In future correspondence please refer to:
Project Tracking Code: 2019-05-03916
Property: Cle Elum Westside Solar Project
Re: Cultural Resources Survey Report Comments

TO: Community Development Services
FROM: Zachery Peebles, Engineering Technician I
DATE: December 17, 2019
SUBJECT: Westside Solar CU-19-00003

Re: CU-19-00003

Project Area
	Sample Plots
	Wetland 1
	50ft Wetland Buffer
	Wetland 2
	25ft Wetland Buffer
	Stream
	20ft Stream Buffer

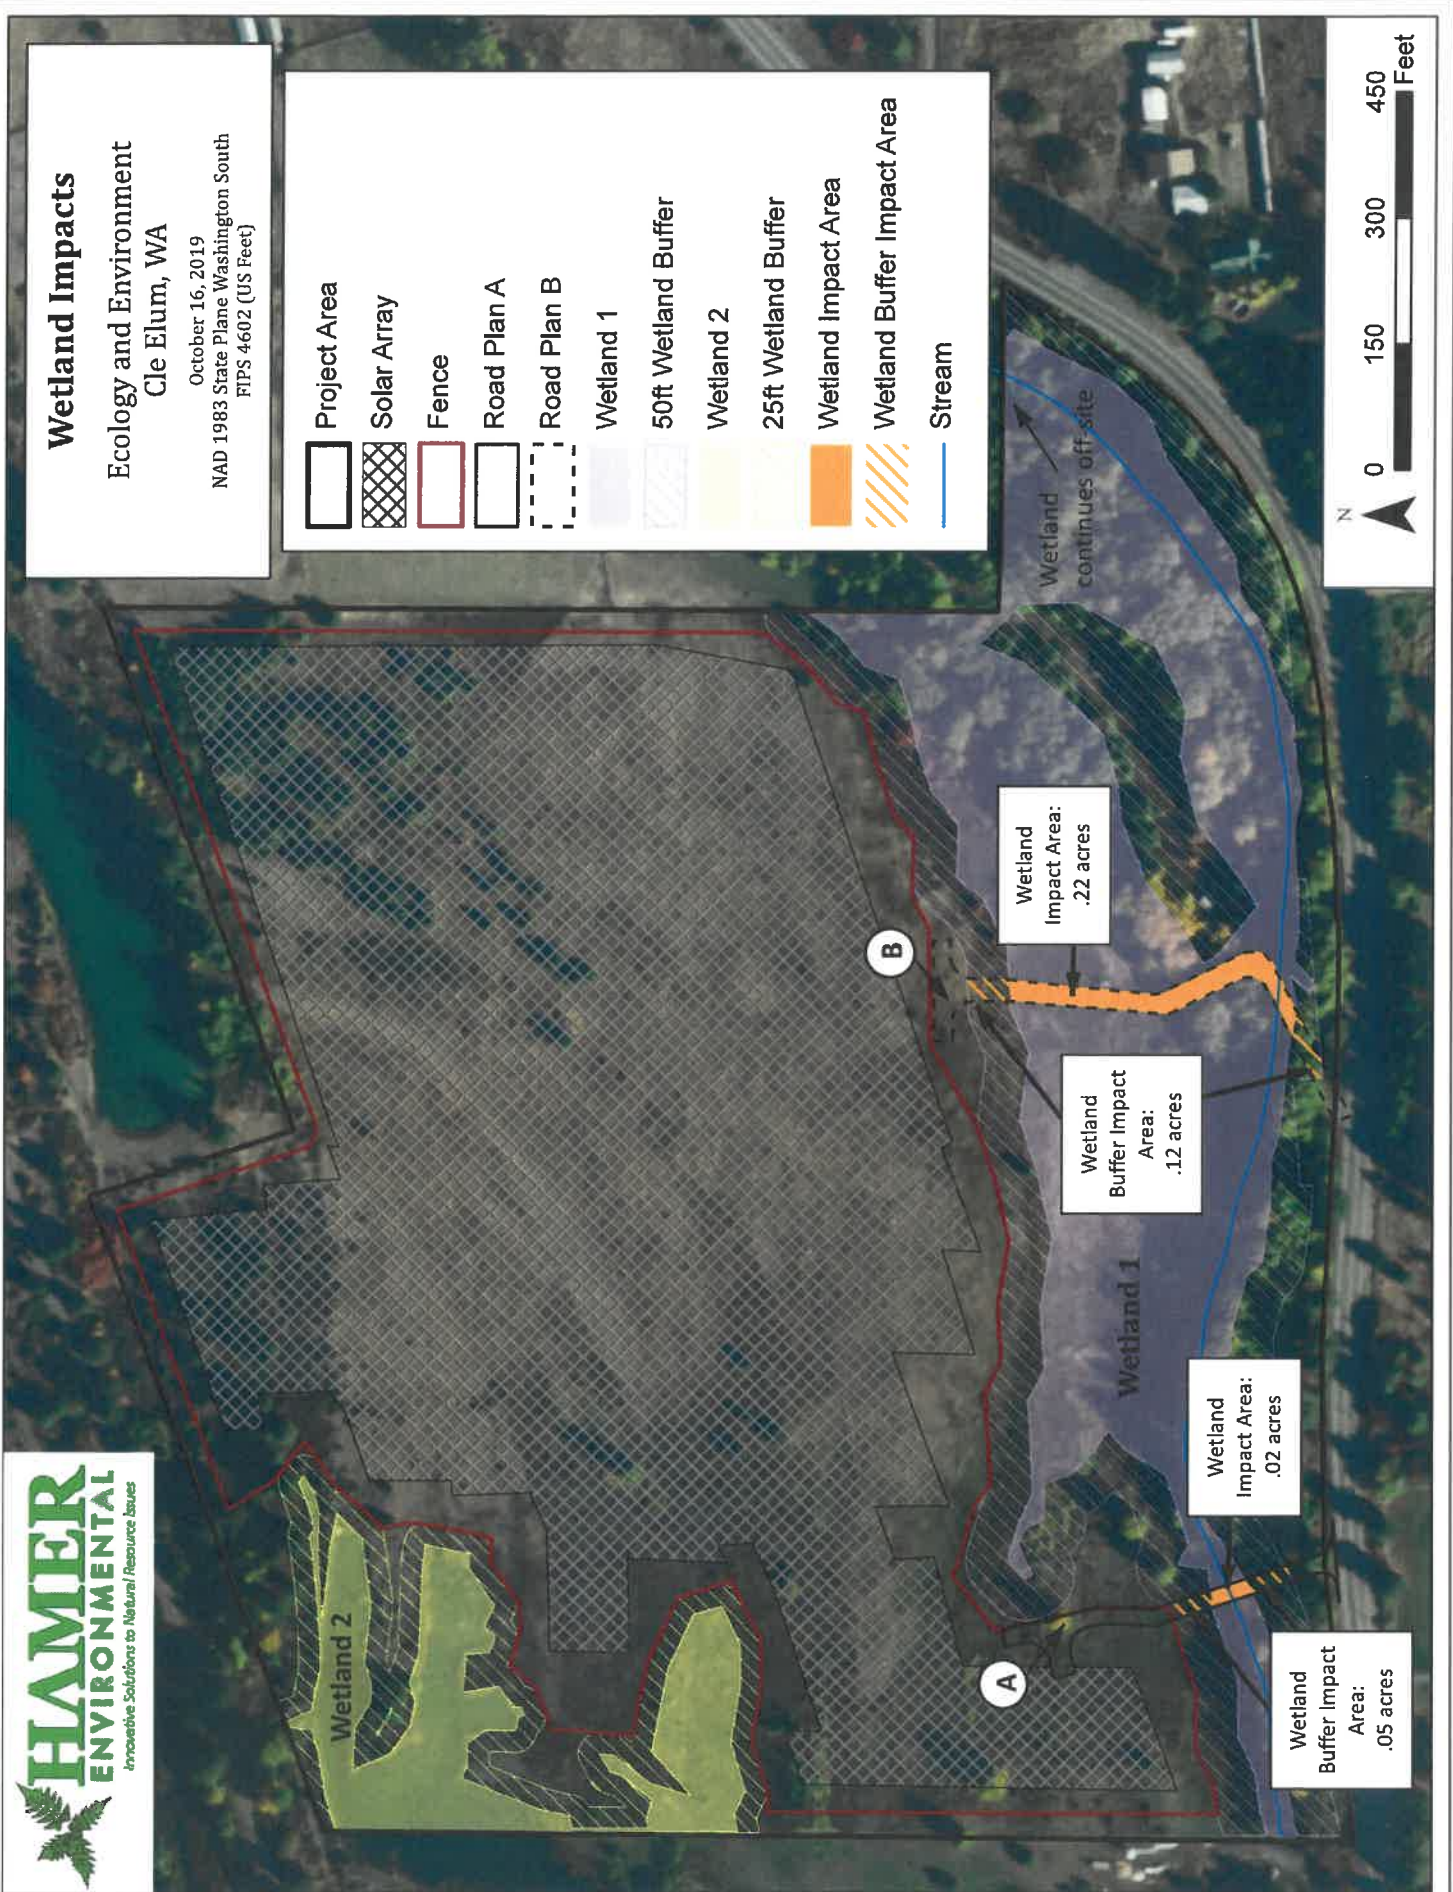
Wetland 2, which will not have any direct impacts, has a proposed 25 foot buffer. Ecology recommends the County to use their widest Category II wetland buffer. Solar farms are considered a high land use intensity and to properly buffer a Category II wetland with a habitat score of 7, Ecology's guidance requires a 150 foot wide buffer. The County's Critical Area Ordinance for Category II wetlands, requires between 25 to 100 feet of upland buffer. Therefore, Ecology would recommend the widest buffer the County's CAO authorizes, which is 100 feet landward of the wetland boundary.

Wetland 1, is a Category I wetland with special characteristics (aspen stand) and a high score of functional habitat (8). This wetland will be impacted; therefore Ecology can require our regulatory buffer guidance to be used. A Category I wetland with a Habitat Score of 8, and surrounded by a high land use intensity would require a 200' wide buffer. However, there is opportunity to reduce the buffer width if the two items in Chapter 6.6.1.1 of Wetland Mitigation in Washington State, Part 1 can be met.

# Proposed Mitigation Plan

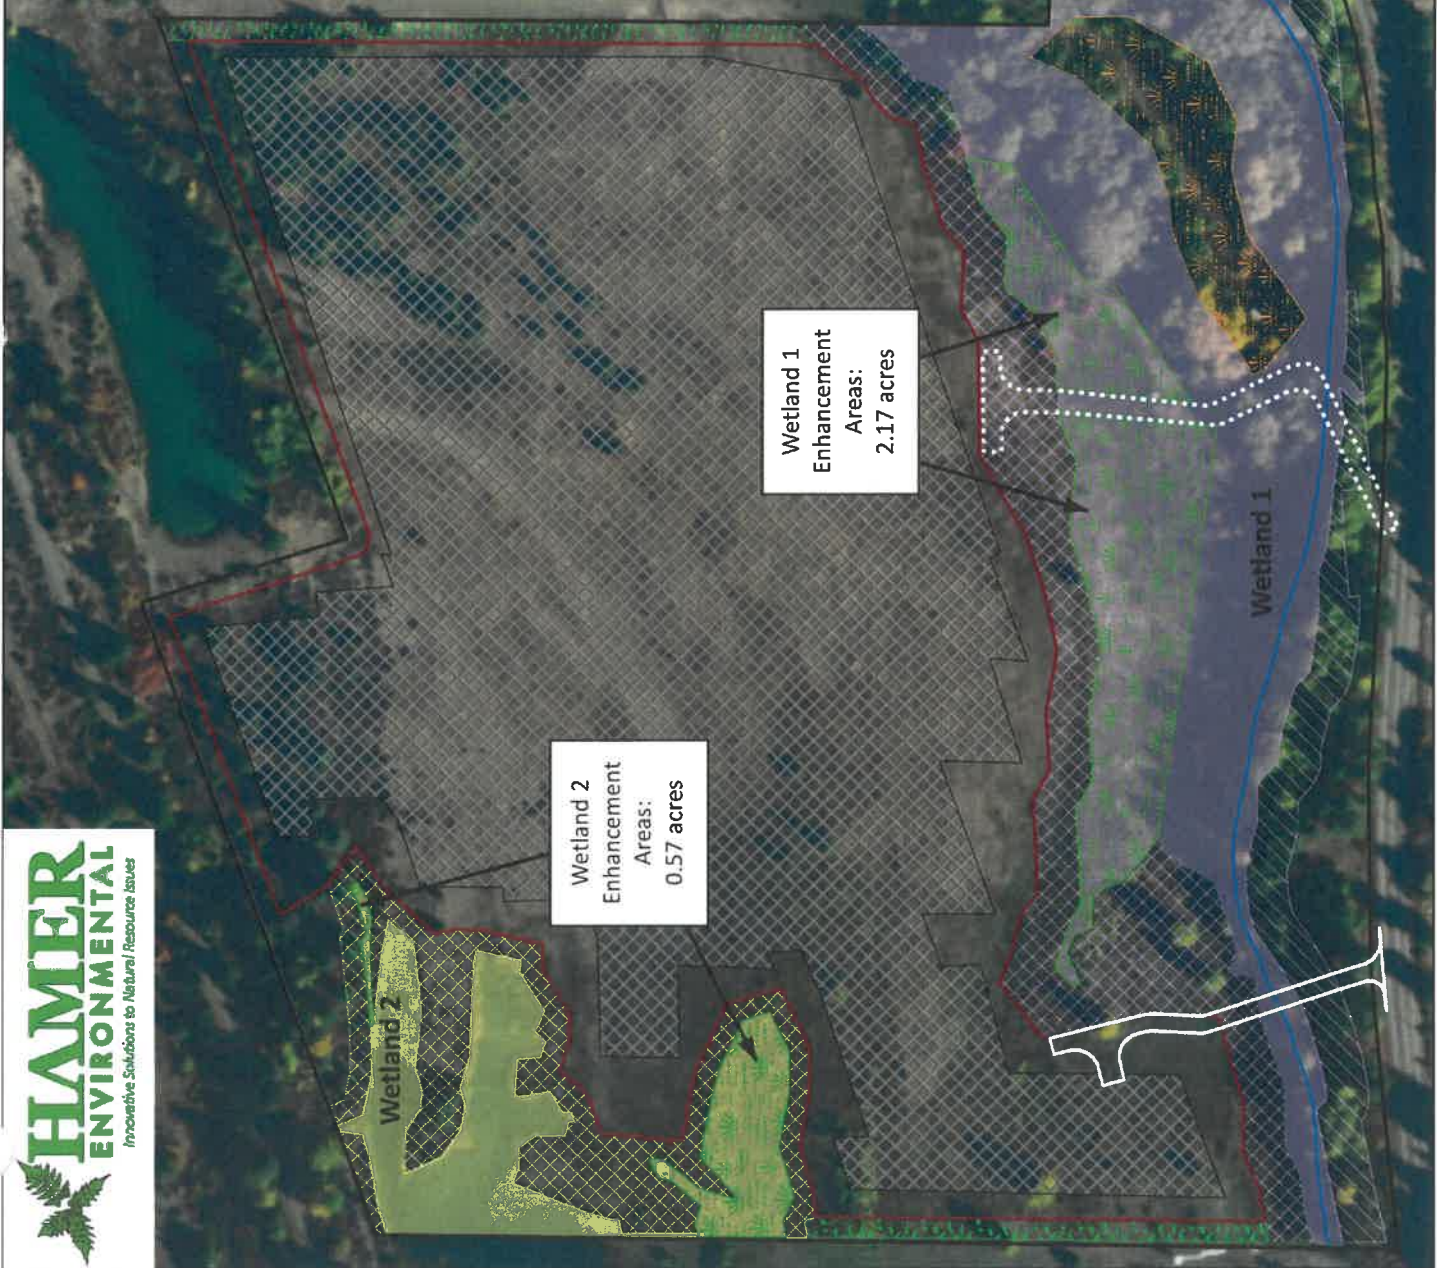
Ecology would recommend access through Alternative A with the use of a culvert to provide hydrologic connectivity.

Mitigation sequencing must be used to avoid and minimize direct and indirect impacts (such as those resulting from the access road) to wetlands.
